Recommendation Report for Planning Permission

REF NO: LU/365/14/PL

LOCATION: 18 Norfolk Road
Littlehampton

PROPOSAL: First floor rear extension to create 1 No 1 bedroom first floor flat & new entrance porch (resubmission following LU/226/13/). This application affects the character & appearance of the Littlehampton Seafront Conservation Area.

PROPOSED NORTH ELEVATION

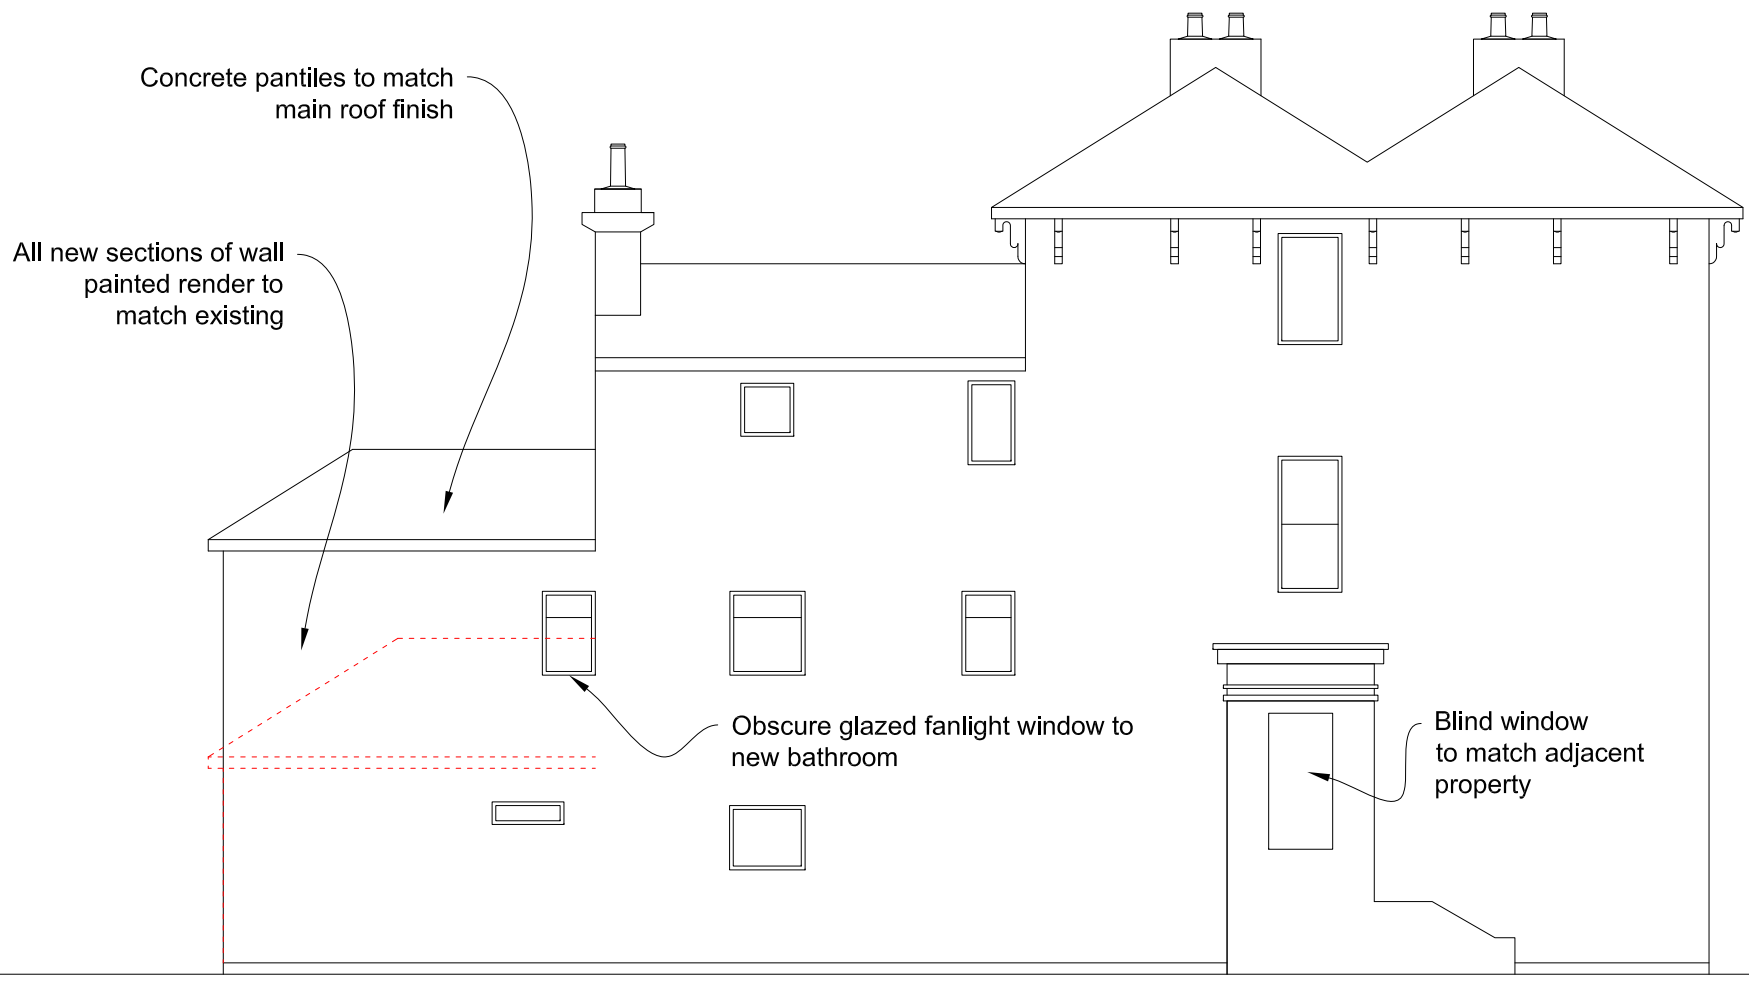
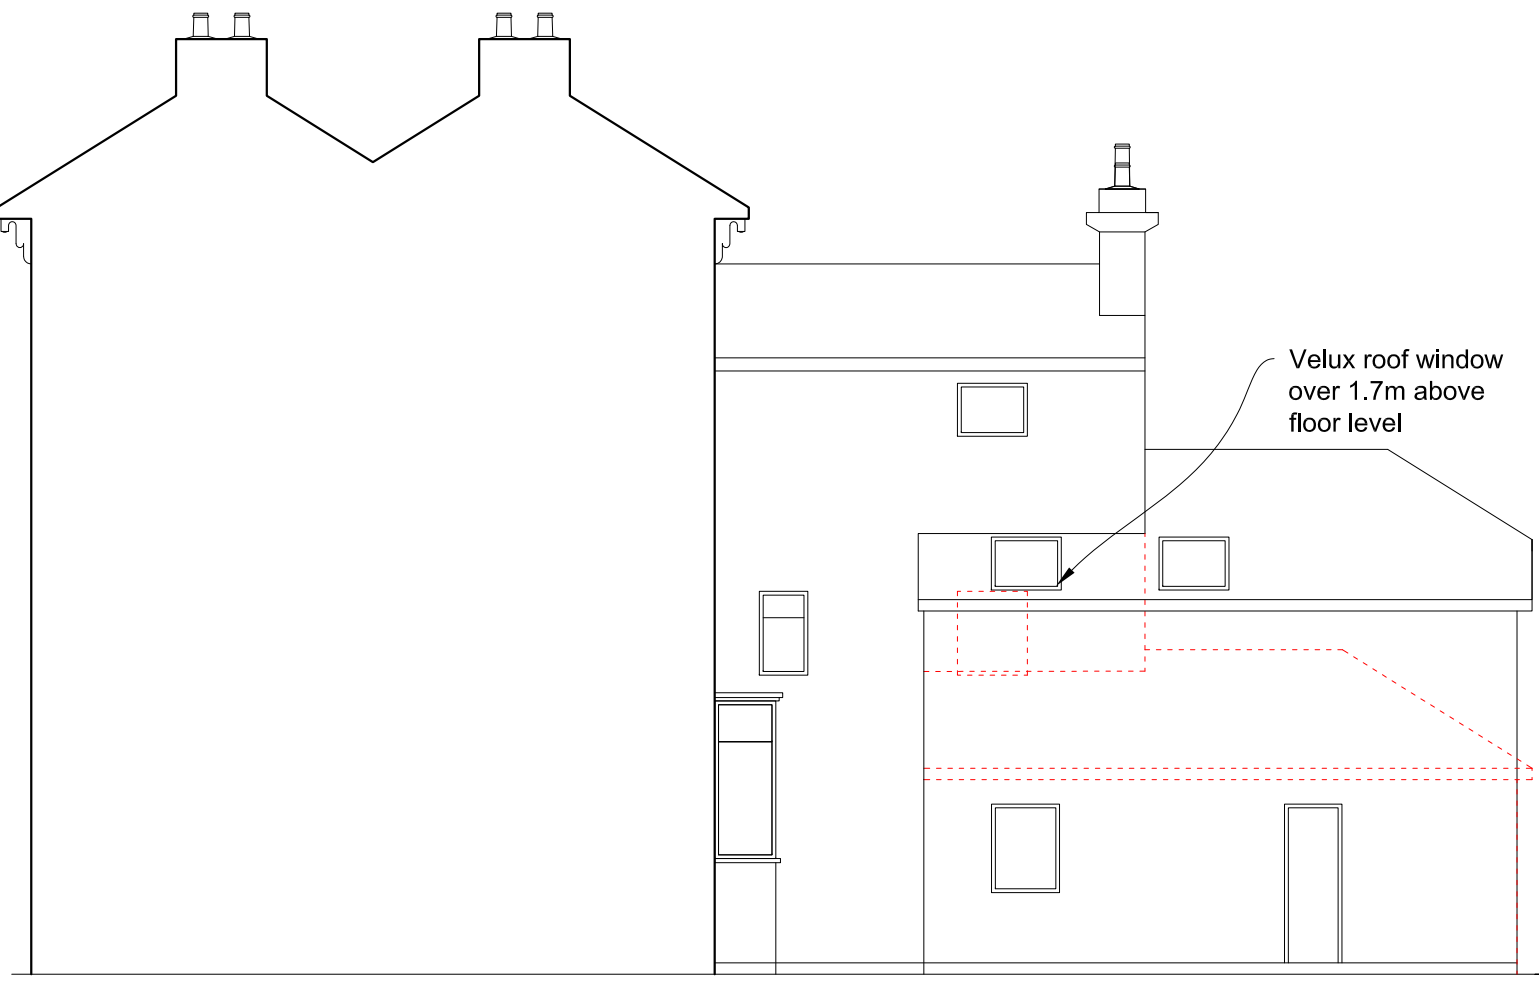
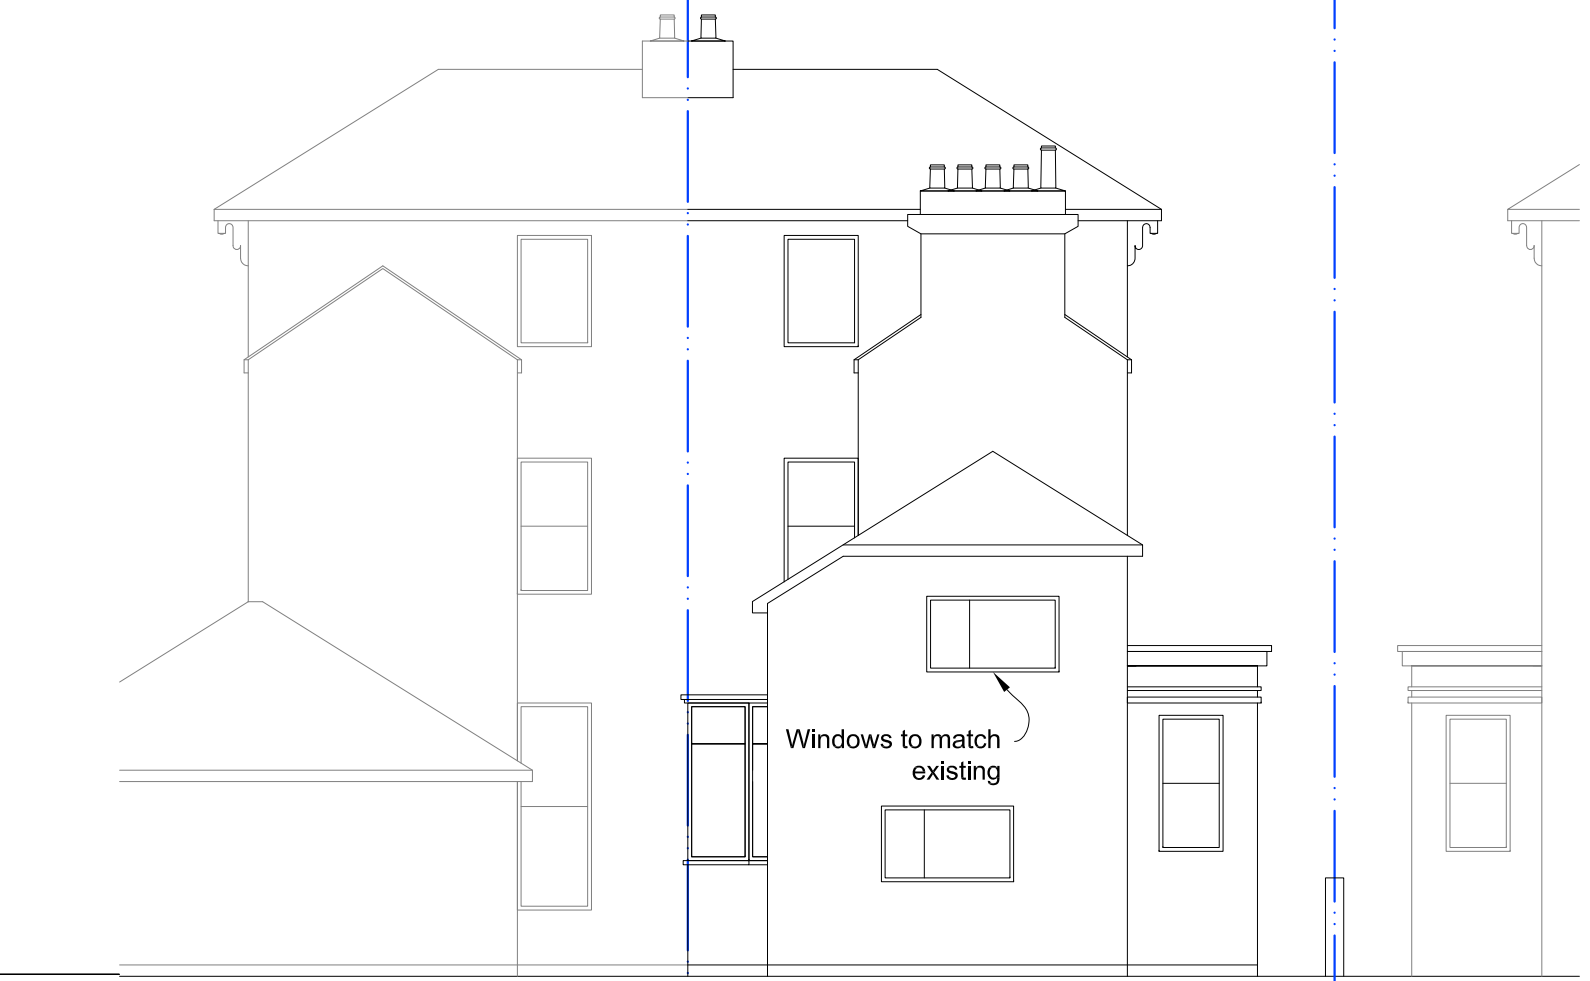
As above. The proposal relates to a first floor extension to the rear to create a one bedroom flat. The extension would project 5m to the rear and have a width of 4.8m. It would extend 1.1m from the side of the property to the north elevation from the side of the property at first floor. The eaves height would be 4.7m high to the north side and the ridge would be 7m high. The entrance porch on the side elevation would be increased in size.

The existing building has been extended at ground floor but still currently conforms with the general pattern of development in the locality. All the properties in this part of Norfolk Road have a lower third storey projection behind the front elevation which extend an identical distance to the rear. The proposed first floor extension would protrude beyond this current rear limit and would appear as a prominent and discordant extension that is out of keeping with the general pattern of development on the locality. The property is readily visible from the south across the parking area behind no. 16 and the extension would not preserve or enhance the appearance of the Conservation Area and would detract from the balanced pattern of roof lines in conflict with policies GEN7 and AREA2 of Arun District Local Plan. In addition, the extension would be prominent in relation to the building as a whole and would not be sympathetic in terms of its form and scale it would therefore be contrary to policies DEV19 and GEN22 of the Arun District Local Plan.

The first floor extension would be located above a ground floor extension and would include an extension on the north side at first floor. The adjacent dwelling is occupied as a single dwelling house and has windows on its south and rear elevation which would lose light. The height of the extension would also result in adverse overbearing effects on the garden area and ground floor

- 1 The site is within an area designated as a Conservation Area under Section 69, 70 and 72 of the Planning (Listed Buildings and Conservation Areas) Act 1990 and the building is defined as a Building of Special Character on the Local List and the proposal by reason of its width, depth, design and height would conflict with the Local Planning Authority's intention to protect and enhance the visual amenities and environment of such areas and the appearance of the existing building and with policies GEN7, GEN22 and AREA2 of the Arun District Local Plan and policies DSP1, DDM1 and HERDM3 of the

- 3 By reason of its height and proximity to the boundary the proposal would result in an unneighbourly form of development which would be detrimental to the residential amenities of the adjoining property to the north, contrary to policies GEN7 and DEV19 of the Arun District Local Plan and policies EDDM4 of the Emerging Local Plan.

PROPOSED FIRST FLOOR

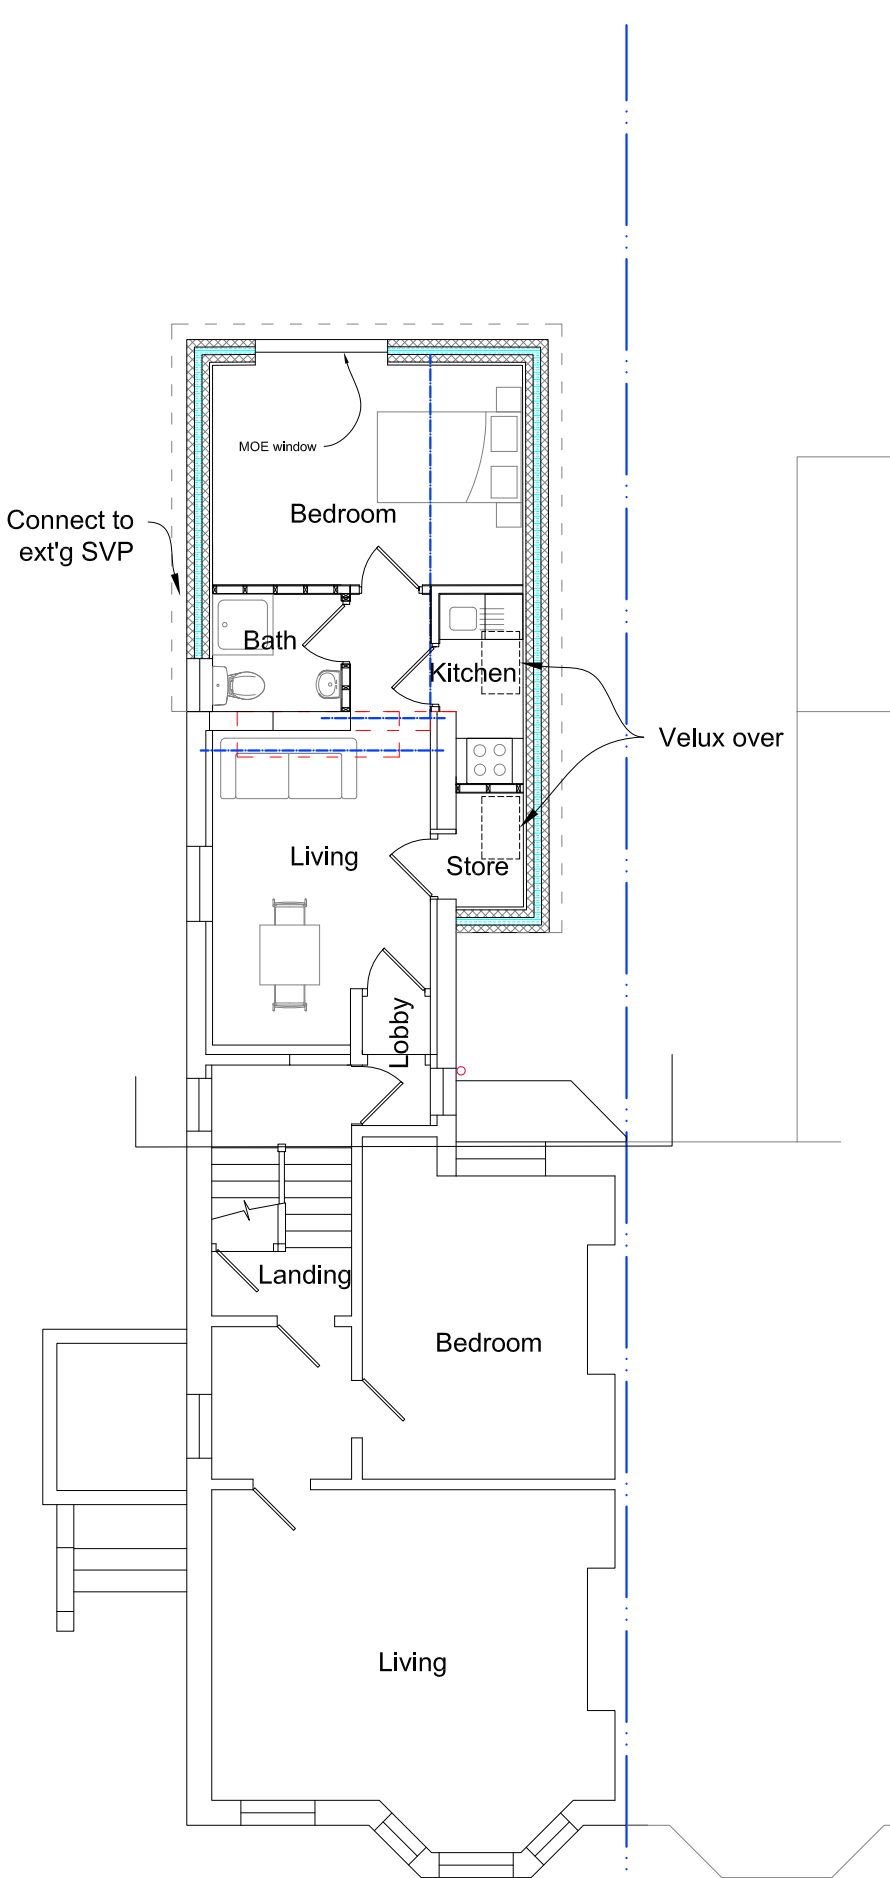
accommodation of the adjacent property. It would therefore be overbearing on the adjoining property in conflict with policies GEN7 and DEV19 of Arun District Local Plan.

The property is currently divided into flats and the extension would increase the total number by one unit. No garden area or outside amenity area is indicated to serve the proposed flat. A garden area and car parking currently serve existing units in the property and no additional provision is made contrary to policy DDM3 of the Emerging Local Plan. In addition, the room sizes would not accord with policy DDM2. The overall internal space requirement for a one bedroom flat is 37sq m and the proposal has a floor area of slightly less than 33 sqm. The kitchen, bathroom and living room are below standard.

- 2 The proposed residential accommodation would not meet the adopted internal and external space standards of the emerging local plan. It would therefore be detrimental to the residential amenities of the existing property and the future occupiers in conflict with policy GEN7 of the Arun District Local Plan and policies DDM2 and DDM3 of the Emerging Local Plan.
